**From:** [REDACTED]  
**To:** [A303 Sparkford to Ilchester](#); [REDACTED]  
**Subject:** Re: A303 Sparkford to Ilchester - noise model Sparkford to Ilchester Dualling Project (TR010036) our ref Long Hazel Park 20014098  
**Date:** 09 January 2019 21:18:32  
**Attachments:** [Appendix C.odt](#)  
[Appendix D.pdf](#)  
[Appendix E.pdf](#)  
[Appendix F.odt](#)  
[Written Statement and Submissions.odt](#)

### **Impact of traffic noise from A303 improvements on Long Hazel Park, Sparkford for Mr & Mrs Alan Walton**

## **Sparkford to Ilchester Dualling Project (TR010036)**

#### **Written Statement and Submissions for Traffic Noise Mitigation by Mr and Mrs A Walton on behalf of Long Hazel Park and Long Hazel Lodges Limited, High Street, Sparkford, Yeovil, BA22 7JH**

Drawing Title
**FIGURE 11.4
NOISE LEVELS IN THE DO MINIMUM DESIGN YEAR
LA10, 18HR [dB] - SHEET 1 OF 4**

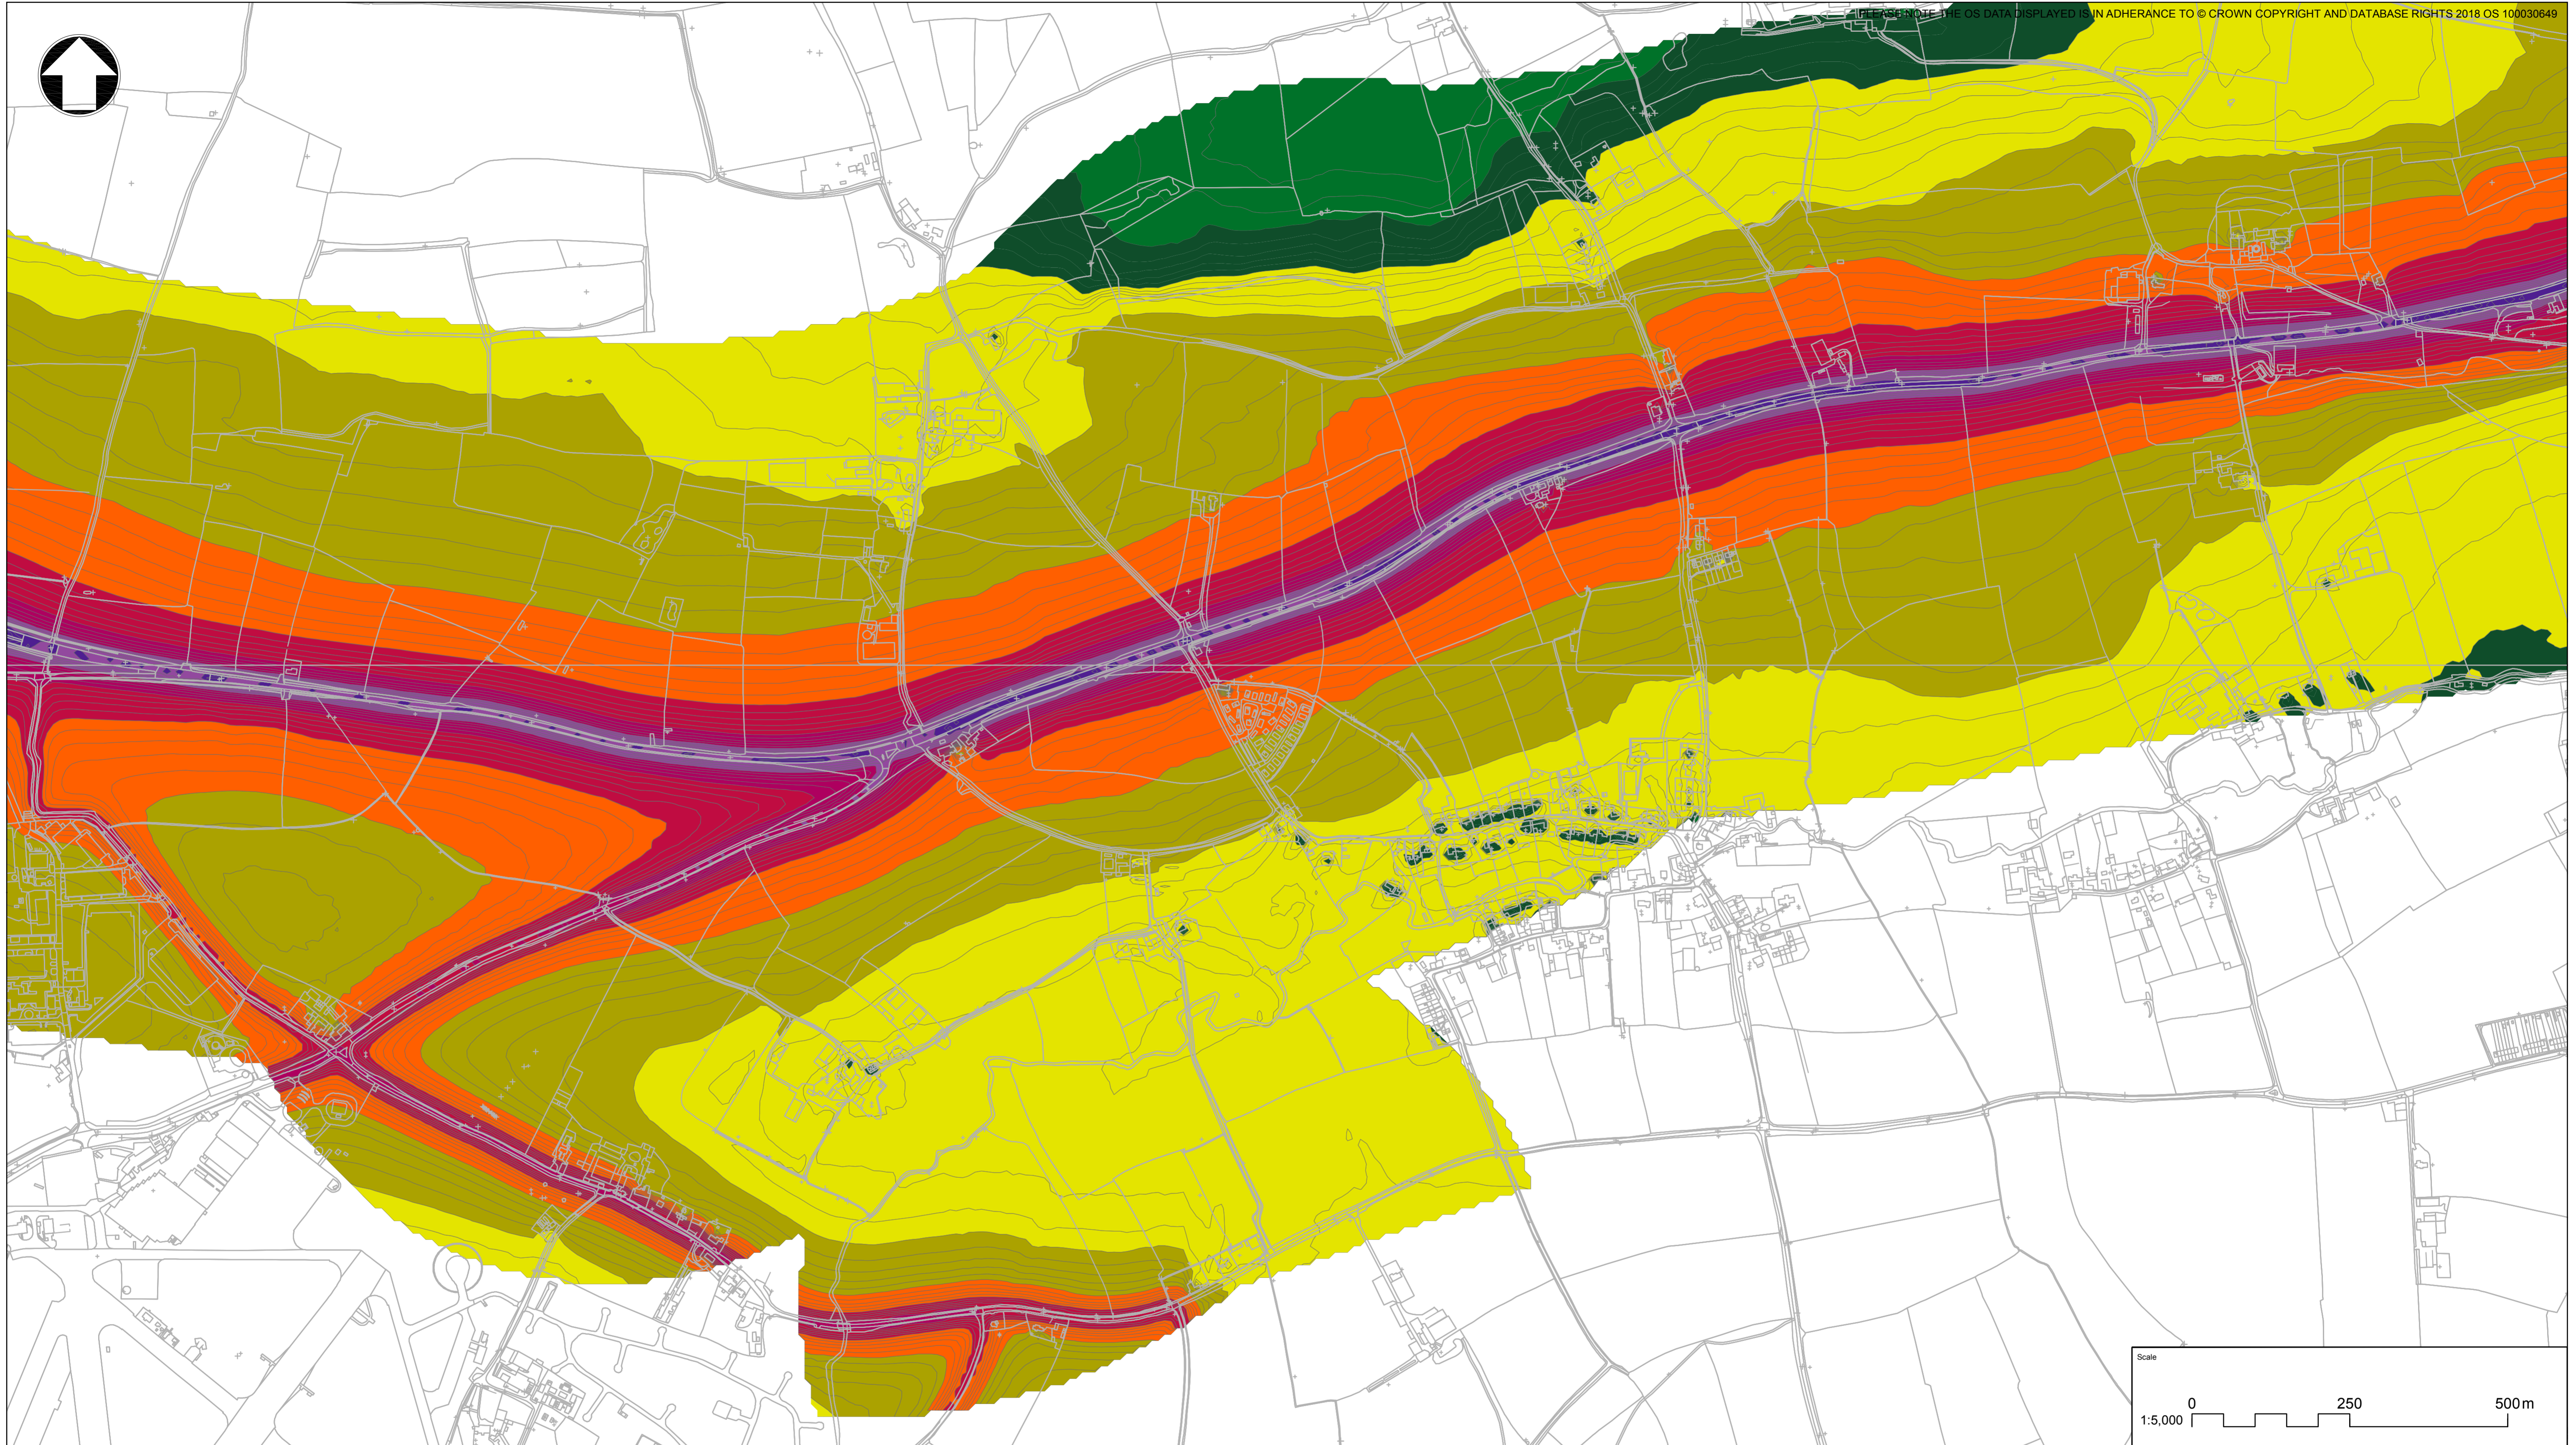
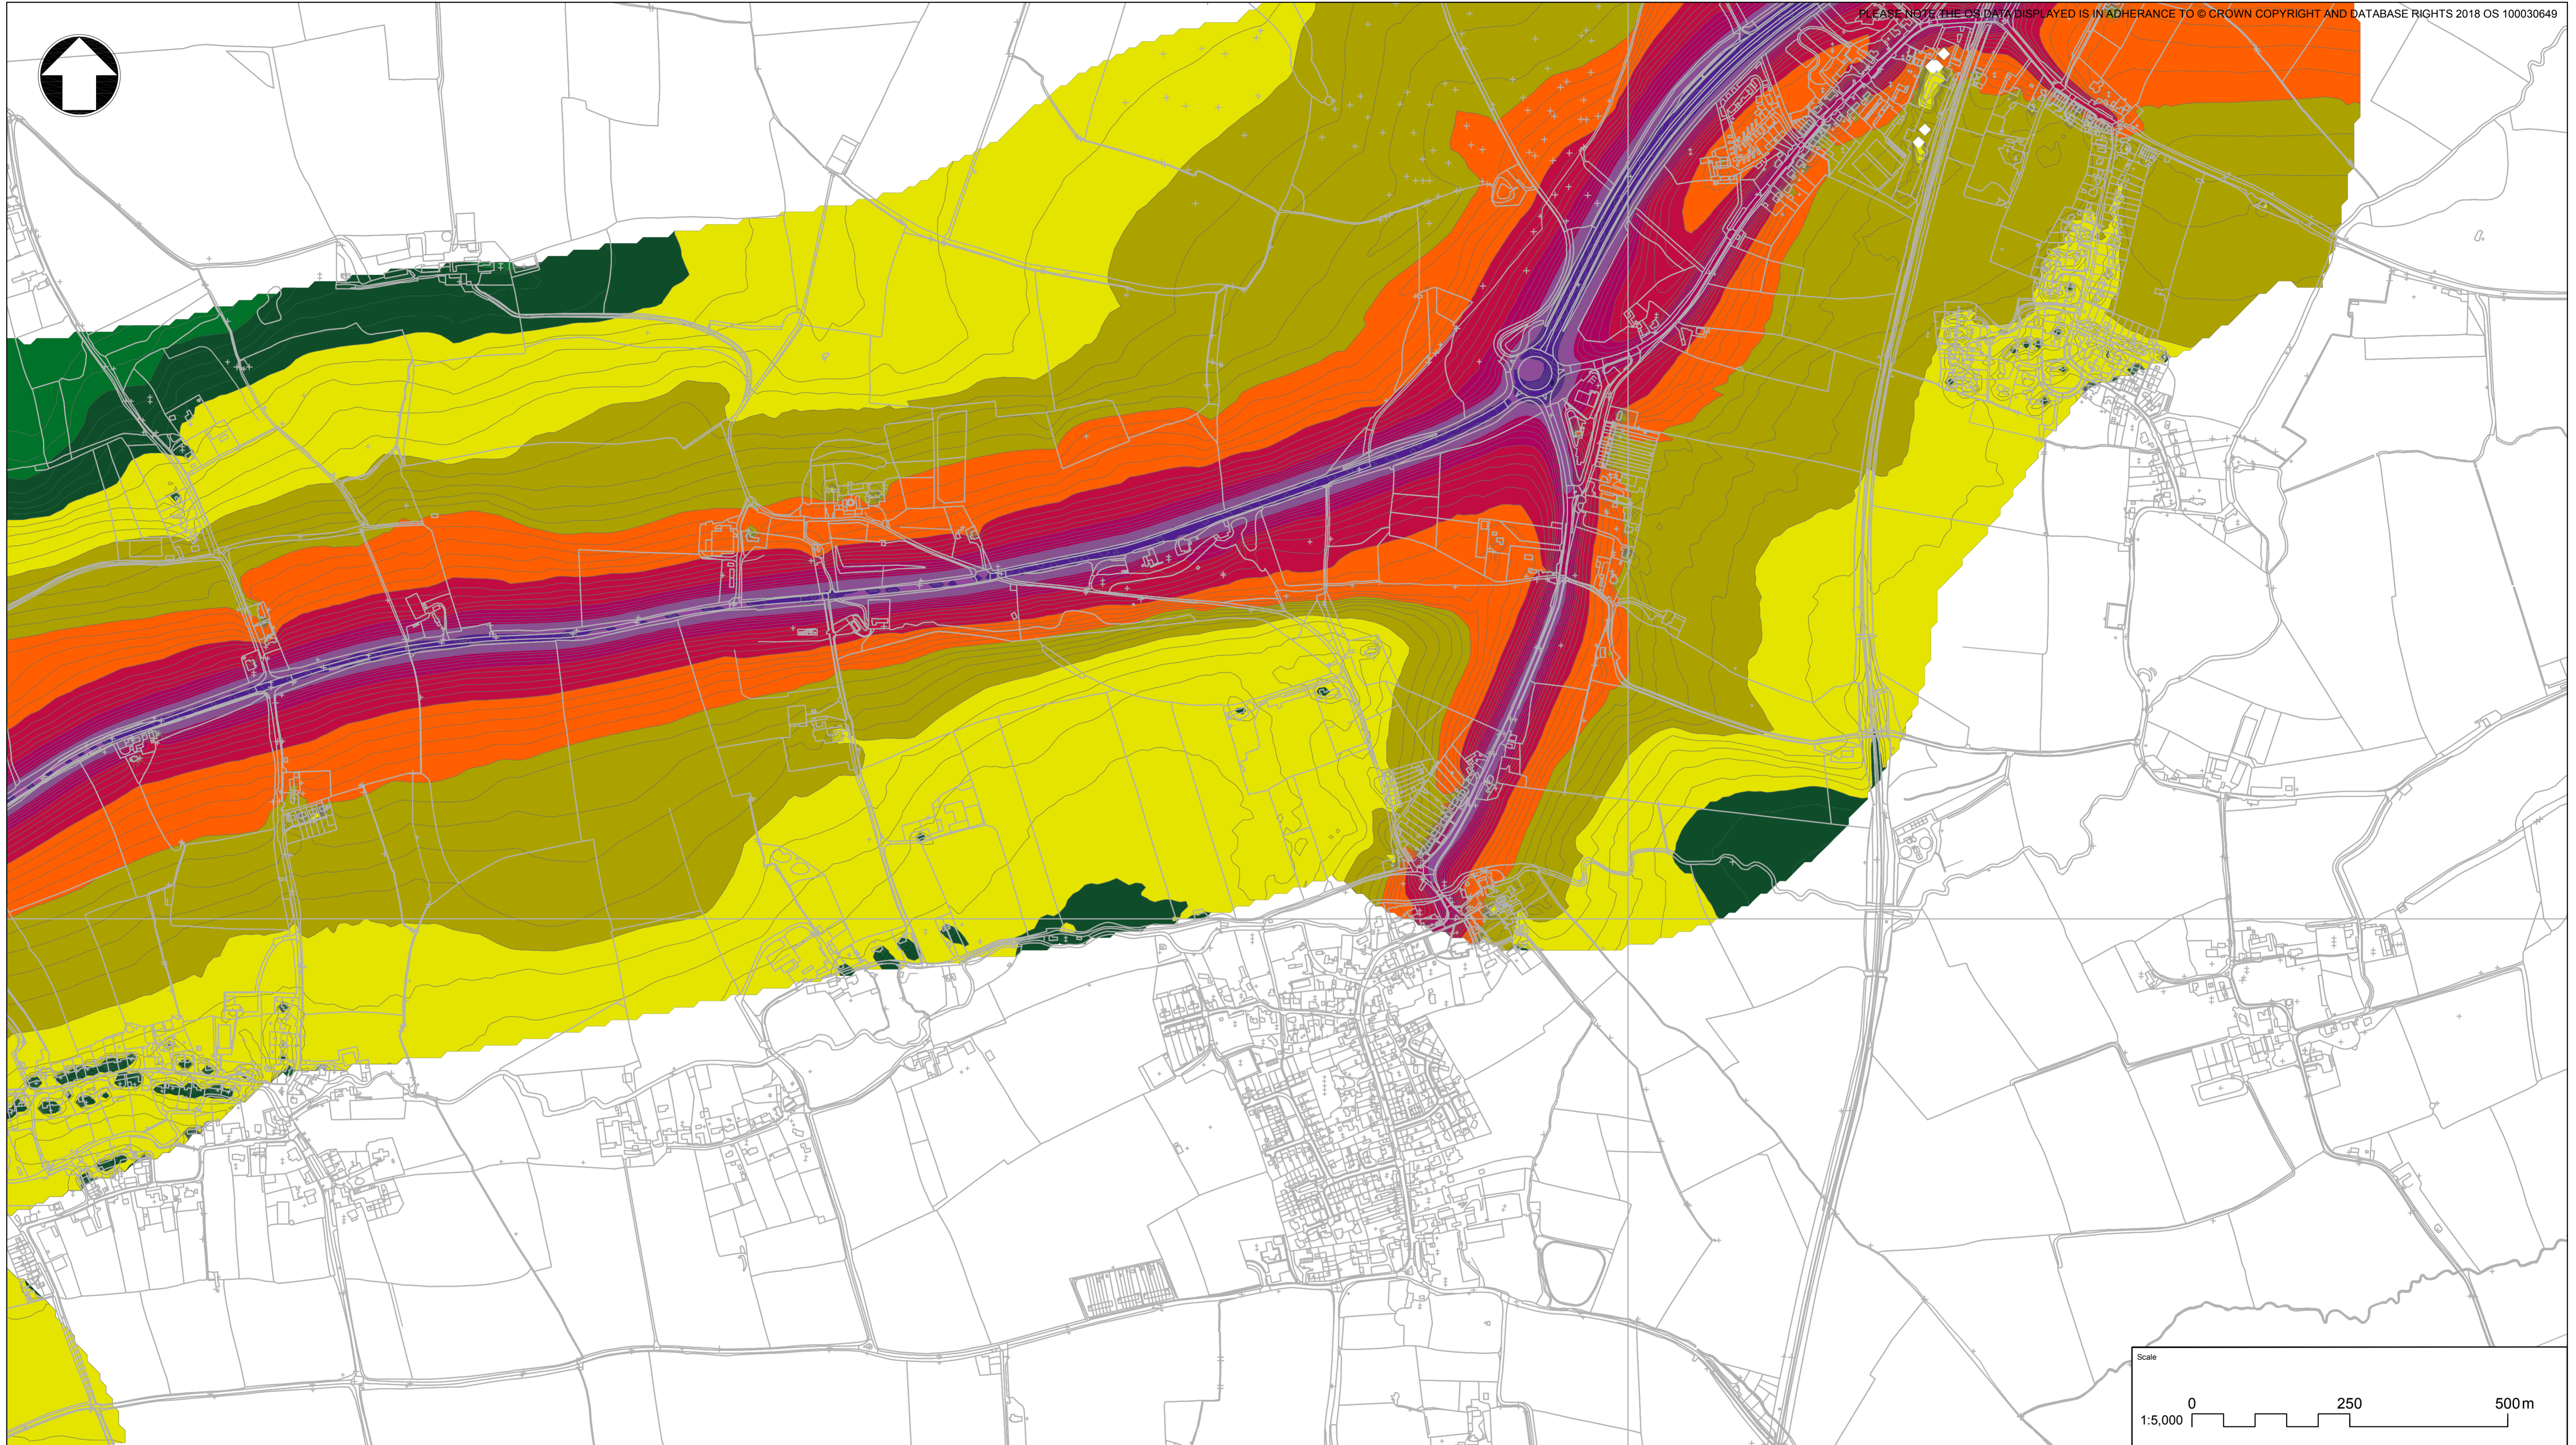
17. Both these areas fall within the applicant's various traffic noise models (sheet 4) which

illustrates projected traffic noise levels of between 55 and 75 decibels to which a factor of 3 decibels should be added as per the report of Mr Tegwyn Jones **Appendix C**.

19. The noise mitigation measures sought are a 3m high traffic noise acoustic barrier between points X and Y on the Plan **Appendix E** preferably extending to Point Z across the end of the adjoining track where it is proposed the footpath across the A303 will terminate. This section Y to Z would act as a bar to the public entering the A303 from this point should the request by the applicants that the pedestrian crossing be terminated. It would be far easier to construct the barrier on our side of the boundary whilst no development is taking place in relation to the six vacant plots closest to the A303. Should the applicant agree to construct the barrier as recommended by Mr Tegwyn Jones we would afford the applicant access to our property for this to be done. We would delay developing the six holiday lodge plots nearest to the A303 until after the completion of the barrier provided this is done before or at the same time that the whole scheme commences. Assuming that a traffic noise reduction surface is going to be provided on the new dual carriageway we would ask that in addition between the point where the new dual carriageway is grafted to the existing A303 at the mid northern boundary point with Long Hazel Park that this surface should be extended to just beyond the northern side slip road to the A359 at the very least. At the grafting point a change in traffic road noise at surface change will be evident and intrusive because unless the surface is all the same traffic will suddenly appear quieter and then be much noisier as it passes on to the untreated surface. We understand this could be by up to 8 decibels in difference. Hopefully the road surface incorporating a traffic noise reduction coat will be upgraded to link up with the recently reduced noise surface at Chapel Cross which continues on to Wincanton. Where possible a reduction in speed limit could be imposed say to 50mph on the new proposed west bound slip road to Hazlegrove Roundabout for Sparkford Village as well as a noise reduction surface. This proposed slip road is presumed to commence in the vicinity of the northern boundary of Long Hazel Park with the A303 and this speed limit with appropriate noise reduction surface will mitigate traffic noise for the benefit of the village as well. It is also requested that an acoustic noise reduction barrier be erected along the length of the said slip road and corresponding barriers on the A303 west bound at Camel Hill especially where the road section is elevated. This is because the prevailing wind from the west blows the traffic noise in to our park and is a constant irritation to our guests and ourselves.
